## KITTITAS COUNTY COMMUNITY DEVELOPMENT SERVICES

January 14, 2015

**RE: Transmittal of Comments – Sun Dog Short Plat (SP-14-00005)**

### SUN DOG SHORT PLAT

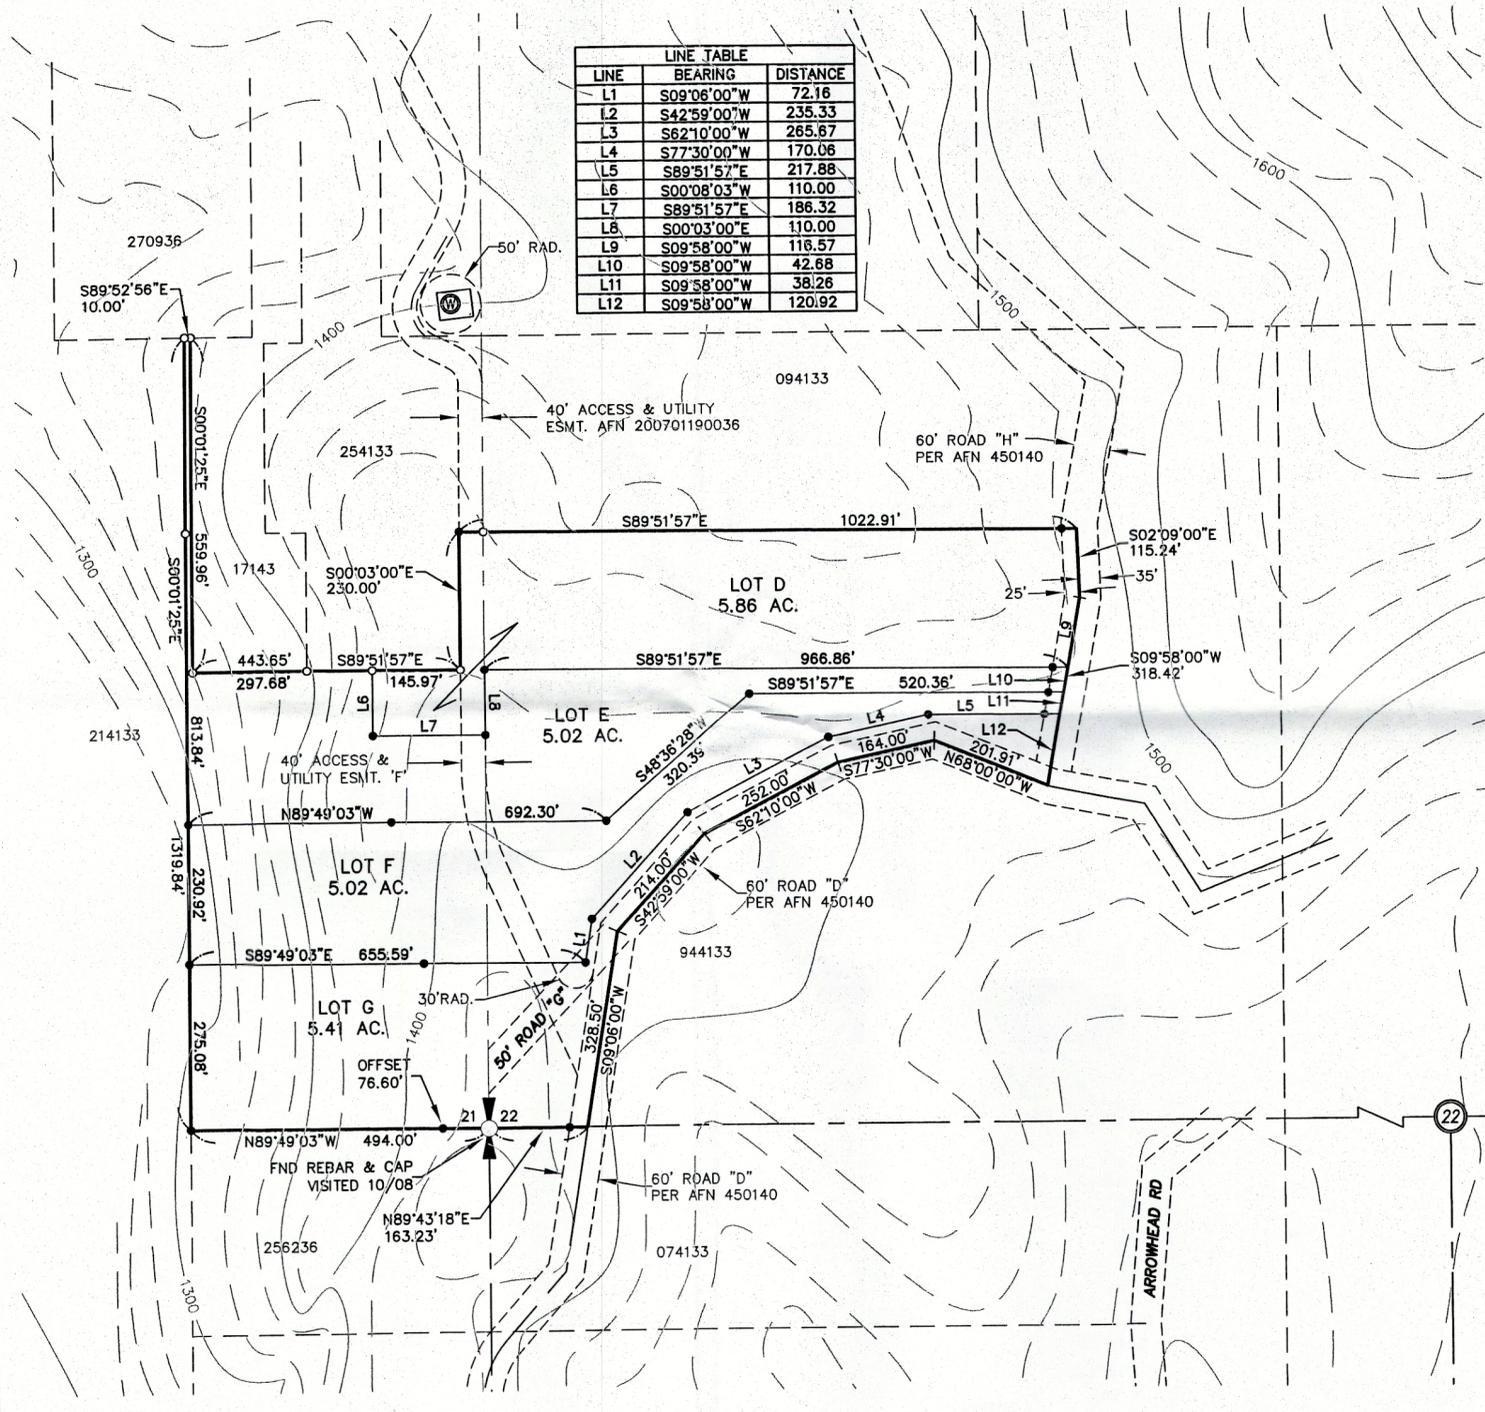
I have requested additional information from the applicant regarding the Sun Dog Short Plat. The issue is that during review of the original Take Five Plat, access to the lots was identified by the surveyor as roads D and H, which are 60' easements. This was acceptable.

Today, if you look at aerial photos it looks like there are building sites and driveways coming off road F, which is only a 40' wide easement. The average lot size in this development is greater than 5 acres and a 60' easement is required.
